From: Aarti O'Leary [REDACTED]
Sent: 01 October 2019 17:16
To: Anita Gardner <Anita.Gardner@arun.gov.uk>
Subject: RE: Application Ref: LU/164/19/PL - 5 Arundel Road, Littlehampton

From: Anita Gardner <Anita.Gardner@arun.gov.uk>
Sent: 01 October 2019 15:55
To: Aarti O'Leary <>
Subject: FW: Application Ref: LU/164/19/PL - 5 Arundel Road, Littlehampton

Condition 3 – I would recommend that the beginning of this proposed condition ‘With the exception of second retention time,’ is removed to read... ‘The extraction system shall be constructed and retained in perpetuity in accordance with the WYG Odour Assessment dated June 2019 and prior to first use of the premises as a hot food takeaway (Class A5), details of the means of odour control required to achieve a 0.4 second retention time through the activated carbon filters to be submitted for approval by the Local Planning Authority. These details shall include the specification for the type of prefilter to be provided.’

Dwg 1915-08B

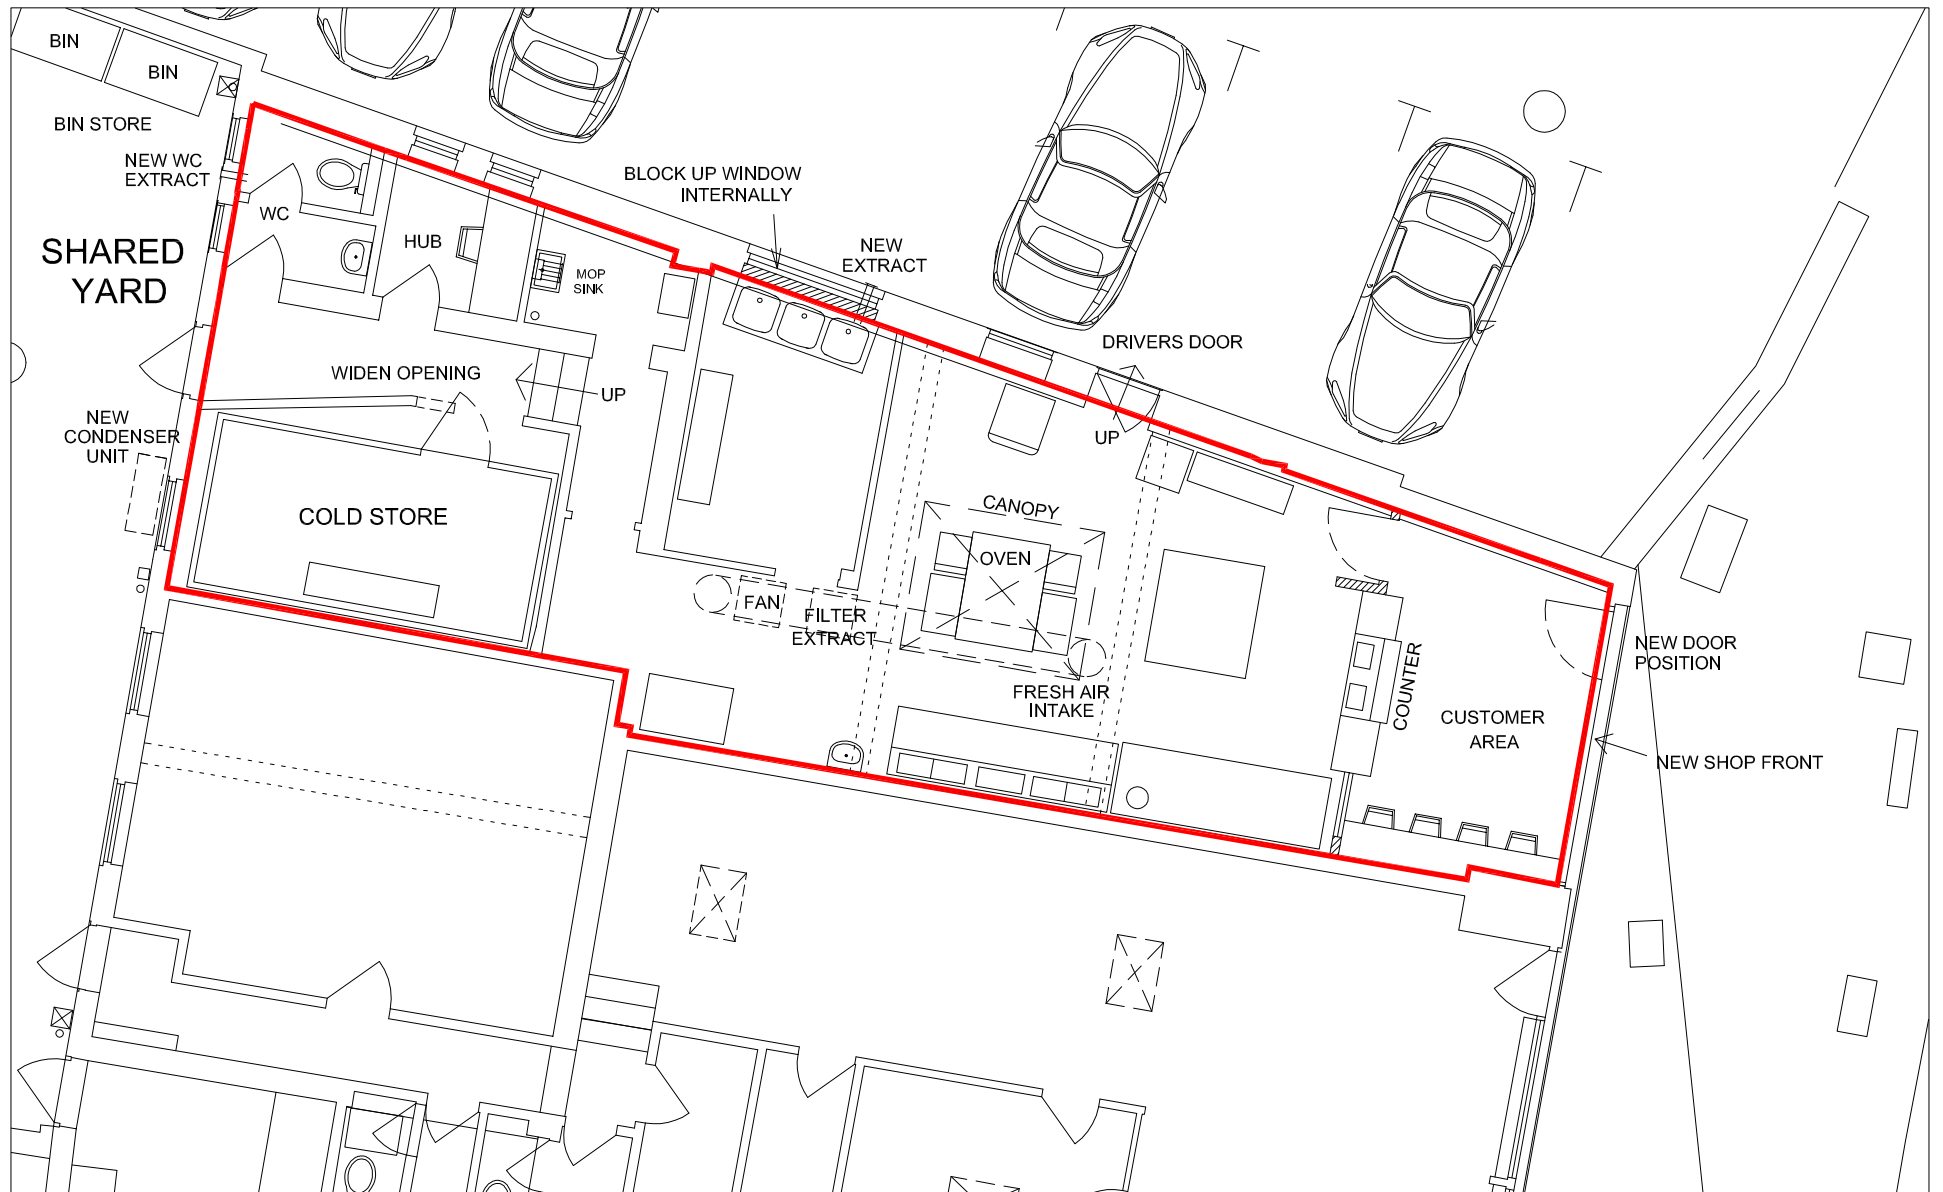
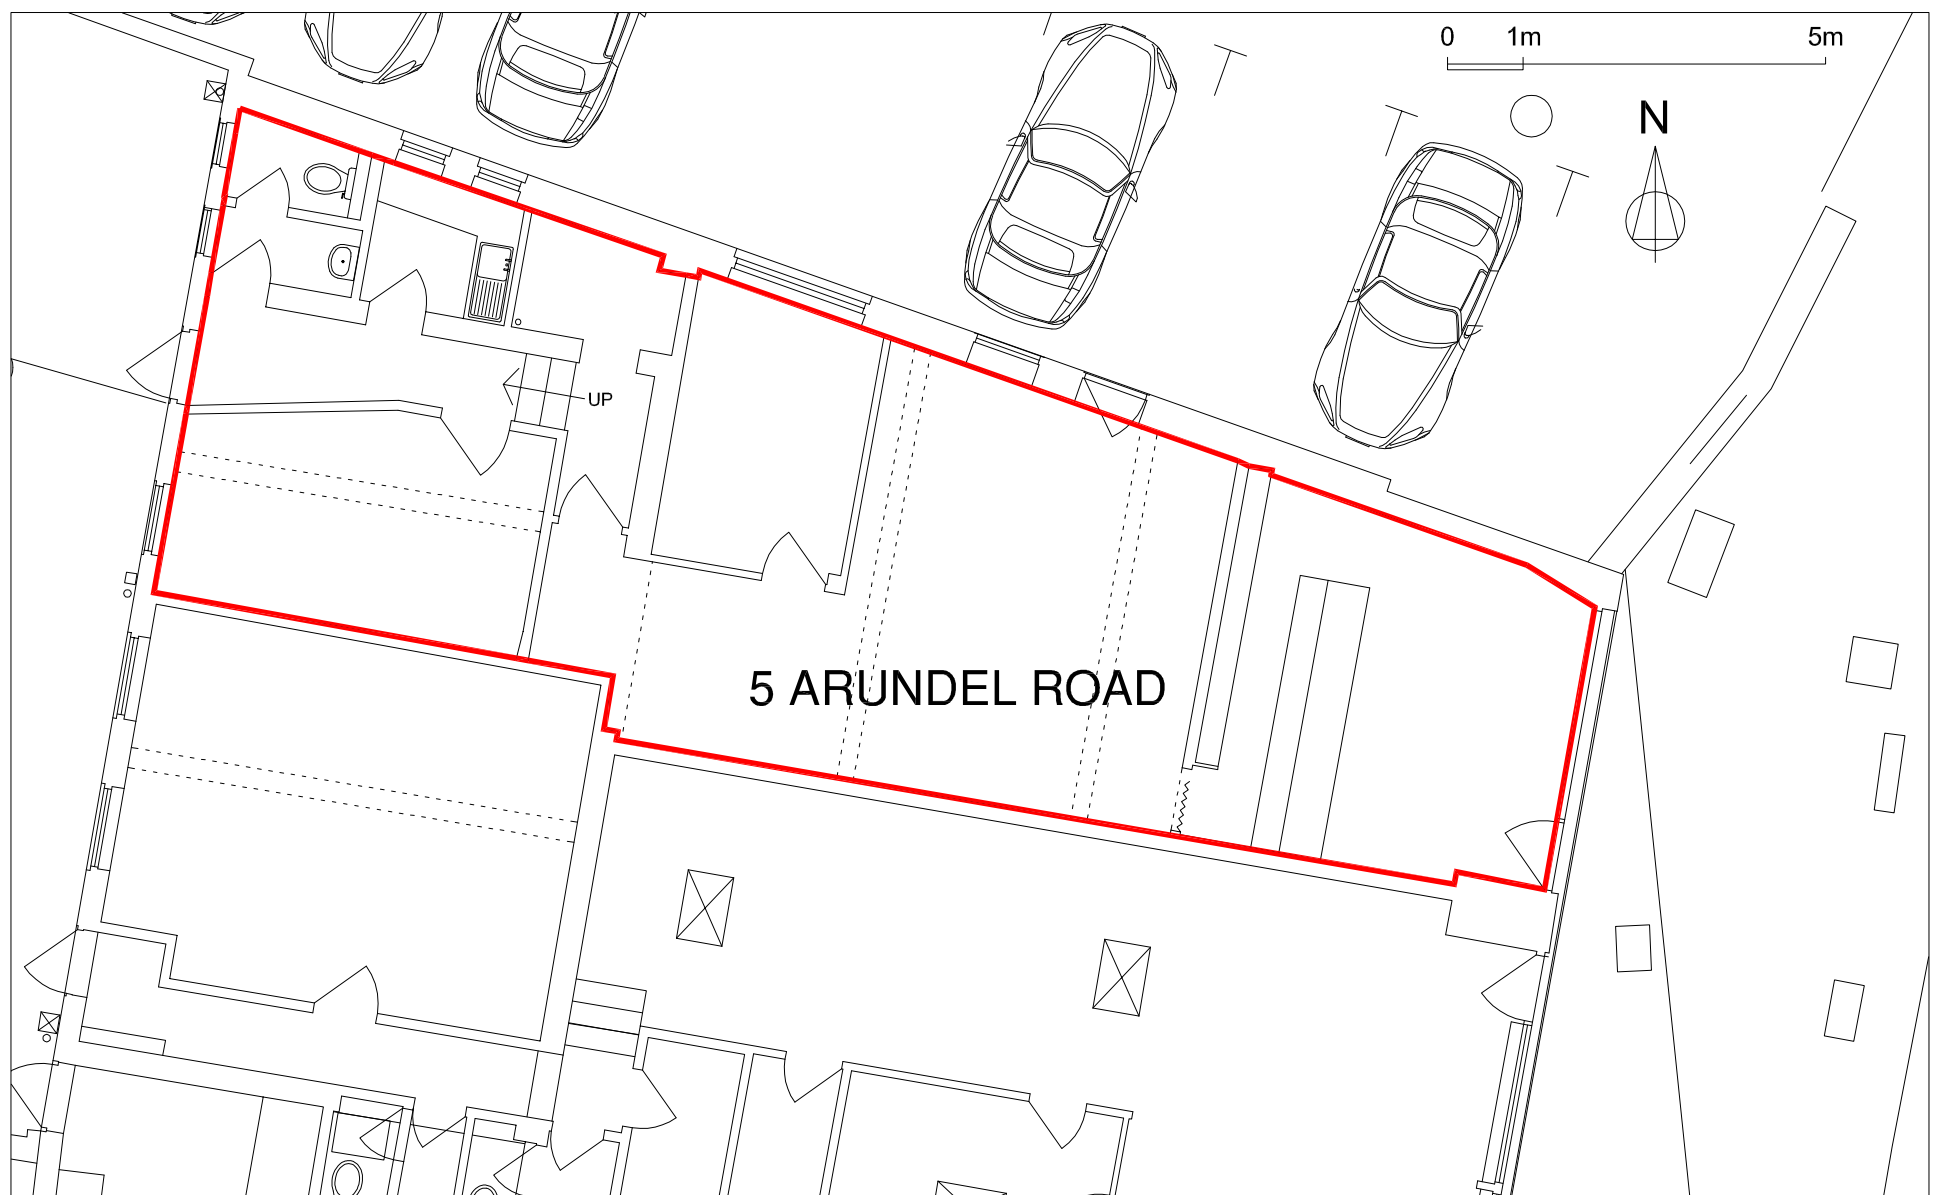
I don't have any plan 1915-08 with revision C. You did refer in your e-mail to drawing C but it is labelled B. Can you clarify please and let me have a copy of C if necessary.

Condition 2 – The 'Change of Use Floor Plans' (ref: 1915-08) should be revision C;

Apologies for the confusion with the Change of Use Plan. So long as the attached version is the one approved, it can be referred to as Revision B in the decision notice.

Dwg 1915-08B

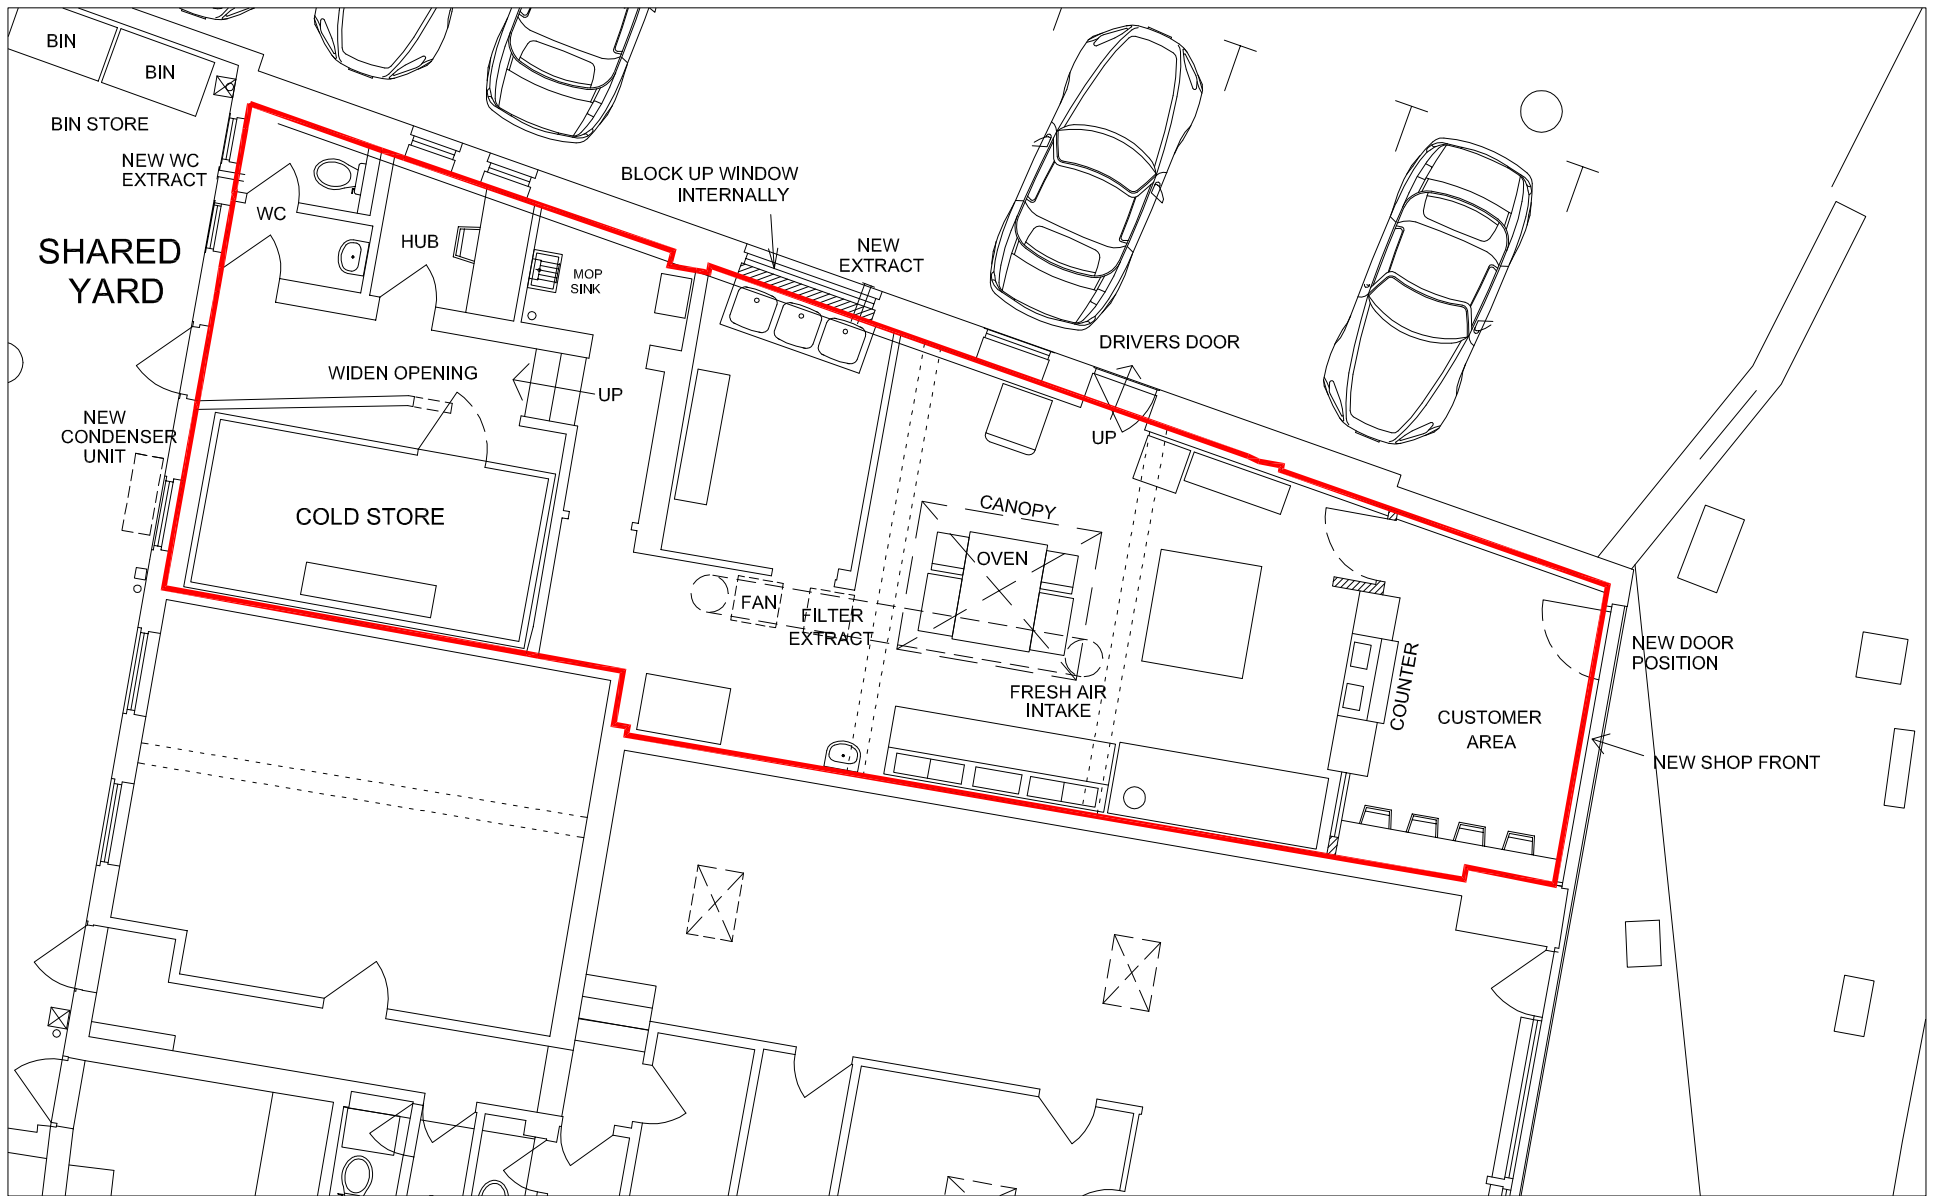
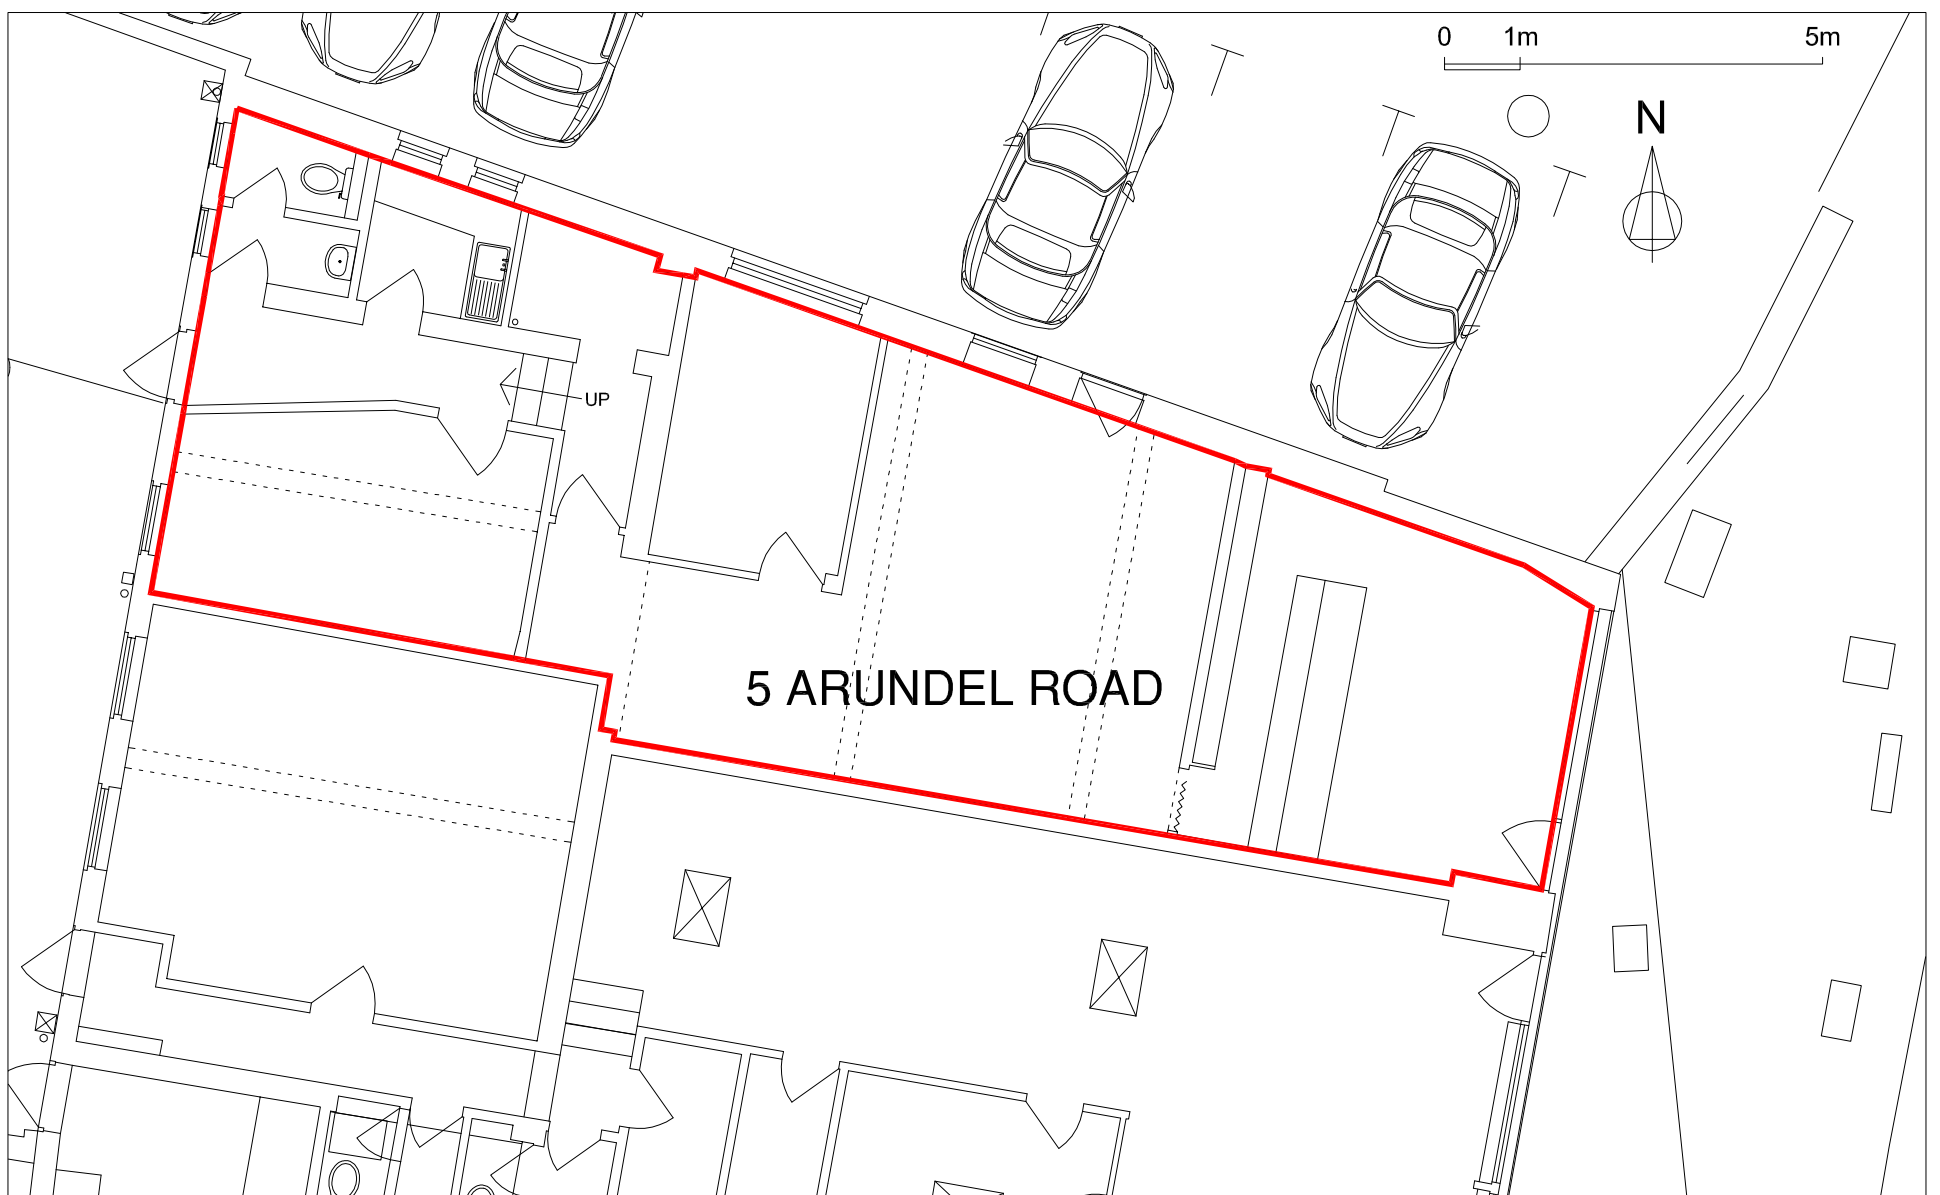
Please note that I am still not satisfied that the submitted internal layout is suitable in this case. Please do not hesitate to contact me again should I be able to provide any further assistance and please if you would, also copy all to Anita.

With regard to internal layout, our technical team has reviewed the plans and advised that alterations to the internal layout would not affect the odour outputs of the proposed development.
